Roundstone Garden Centre, Roundstone By Pass, Angmering, Littlehampton
Non Material Amendment to Application A/33/12

The enclosed application proposes minor changes to the footprint and elevations of the structure approved by application A/33/12 on June 18th 2012. The requirement for these changes has been identified following a full review of the approved scheme at the detailed design stage.

PROPOSED ROOF PLAN

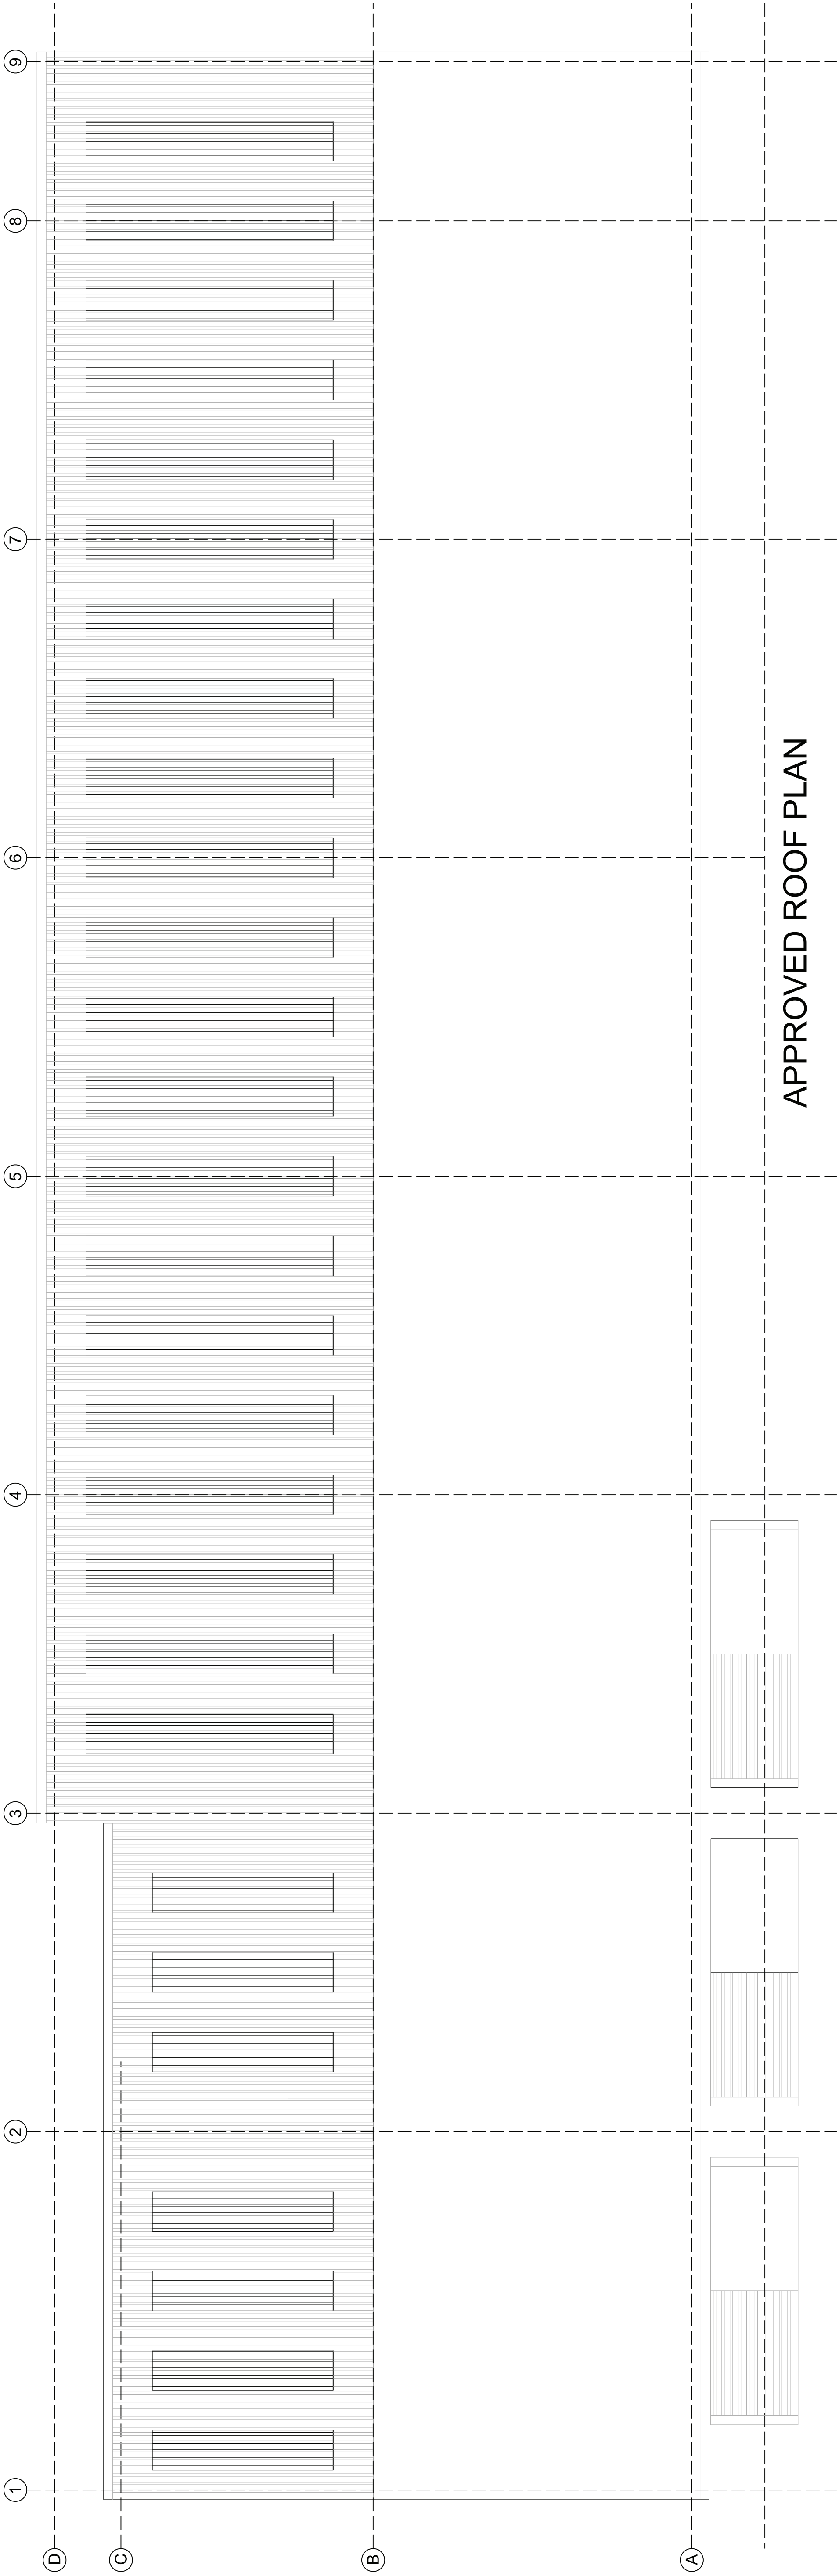
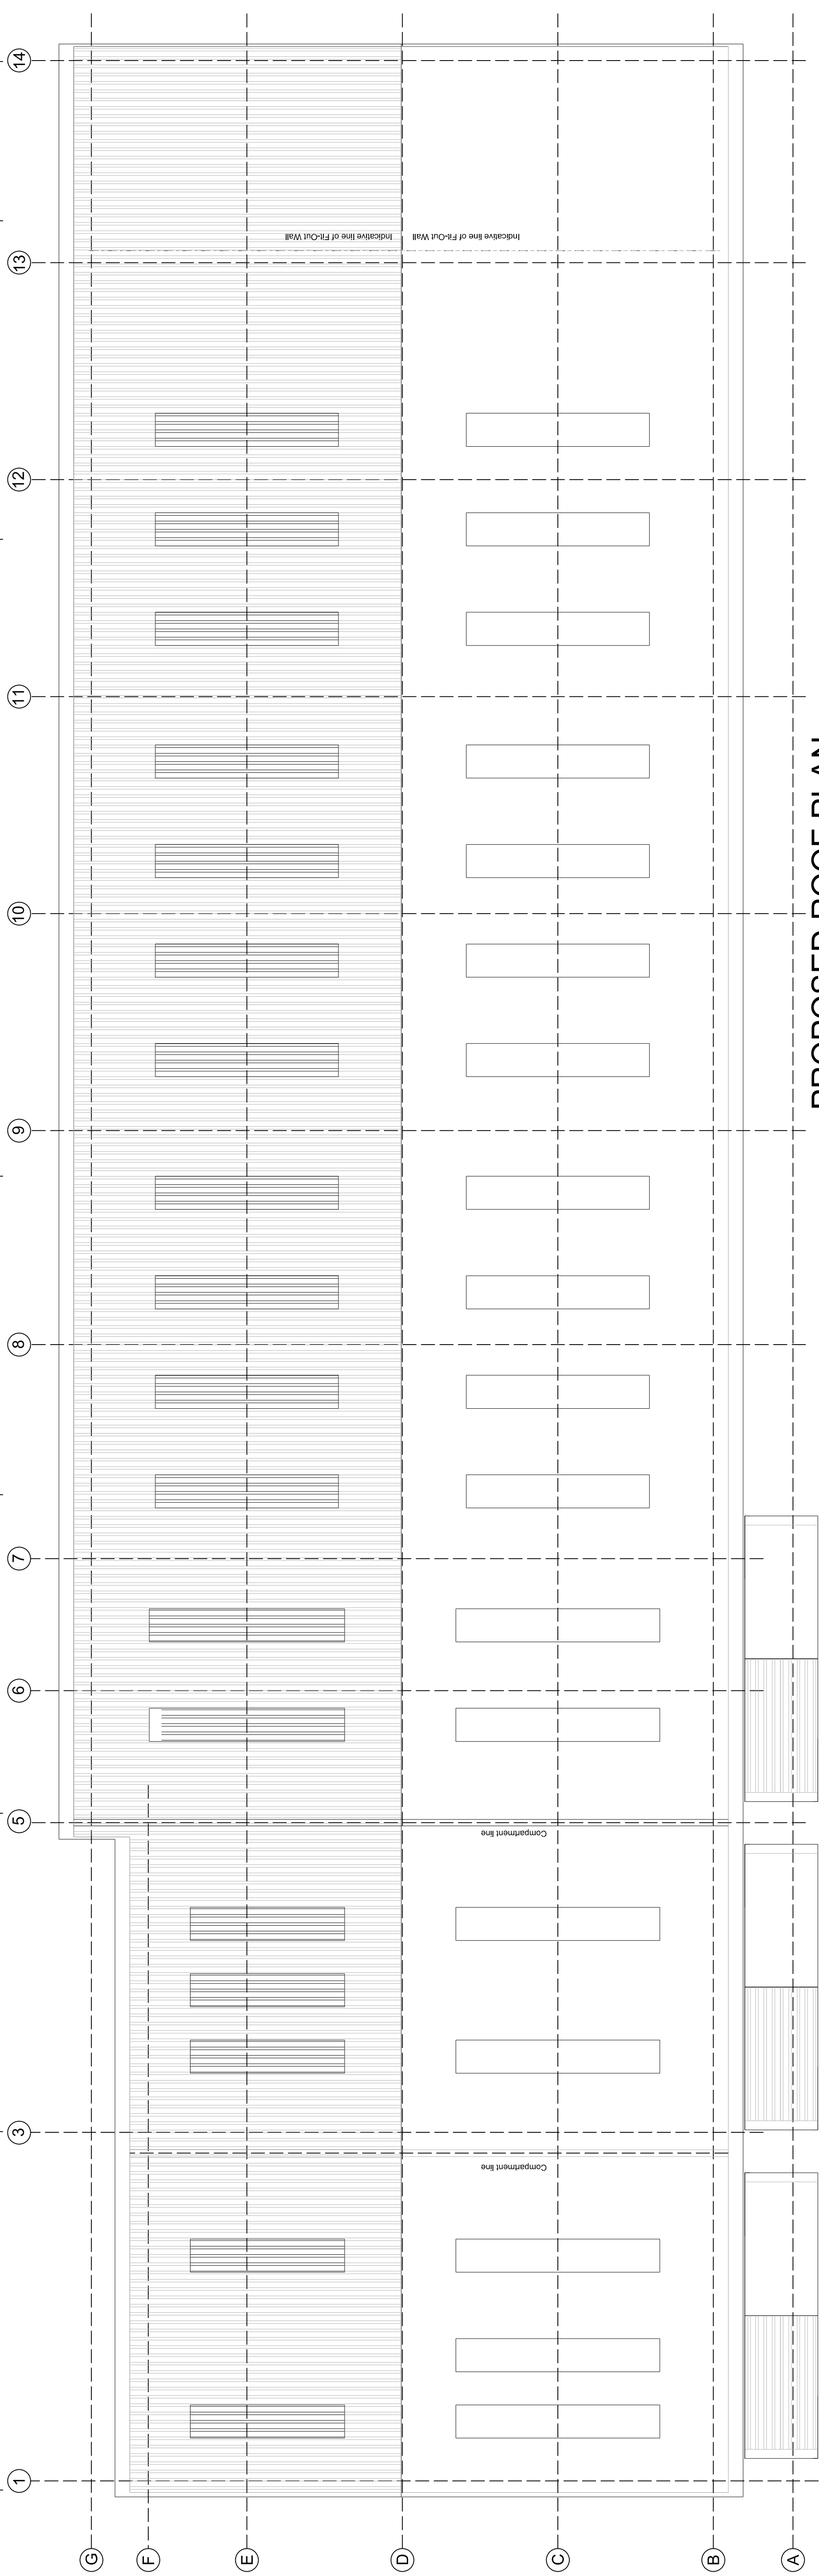
The adjustments to the roof light position and number are also shown in full on drawing 6520/PL(0)22. You will note roof lights are no proposed on both pitches of the roof to enhance the natural light within the units. Furthermore, the roof lights above the mezzanine within unit 3 have been removed.
